**Consultation Response from KC,
Trees**

2023/91626 adj, 275, Longwood Road, Longwood, Huddersfield, HD3 4EL

Demolition of outbuilding and erection of detached dwelling

Date Responded: 10/08/2023

Description  
**Site Plan & Site Section**

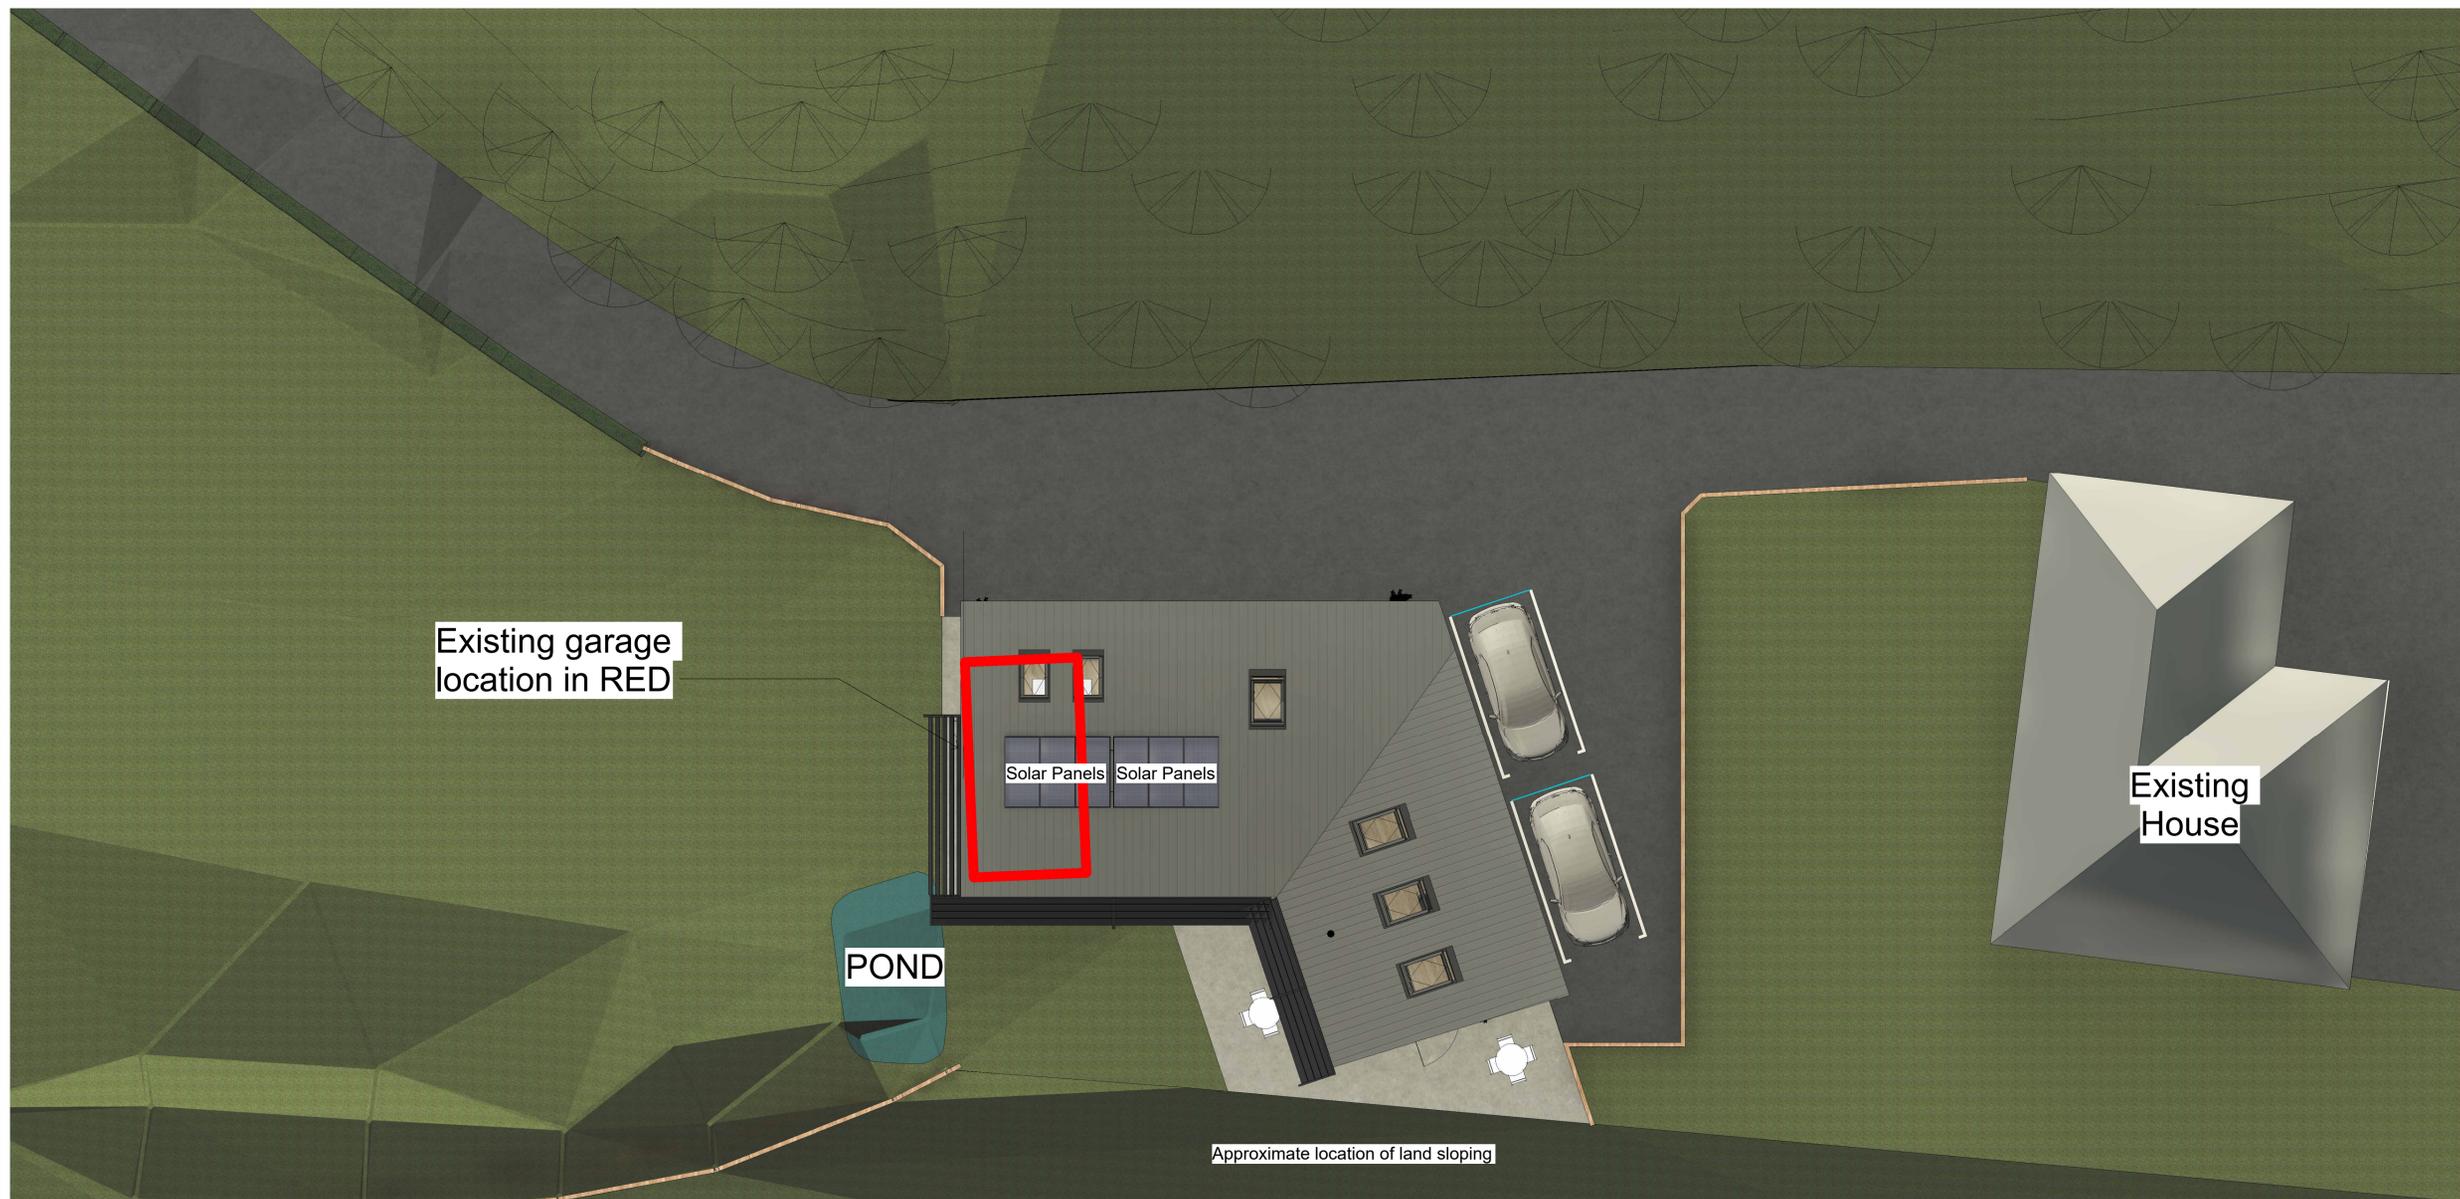
The proposal foreseeably could impact on existing trees both directly and indirectly during construction and once its occupied/in use.

No tree survey information has been provided as with the application and as a result Trees team are unable to make worthwhile comments on the application.

There is an objection to the proposal from an arboriculture perspective because the proposal is conflicting with it conflicts with Kirklees Council's adopted Policy LP33.
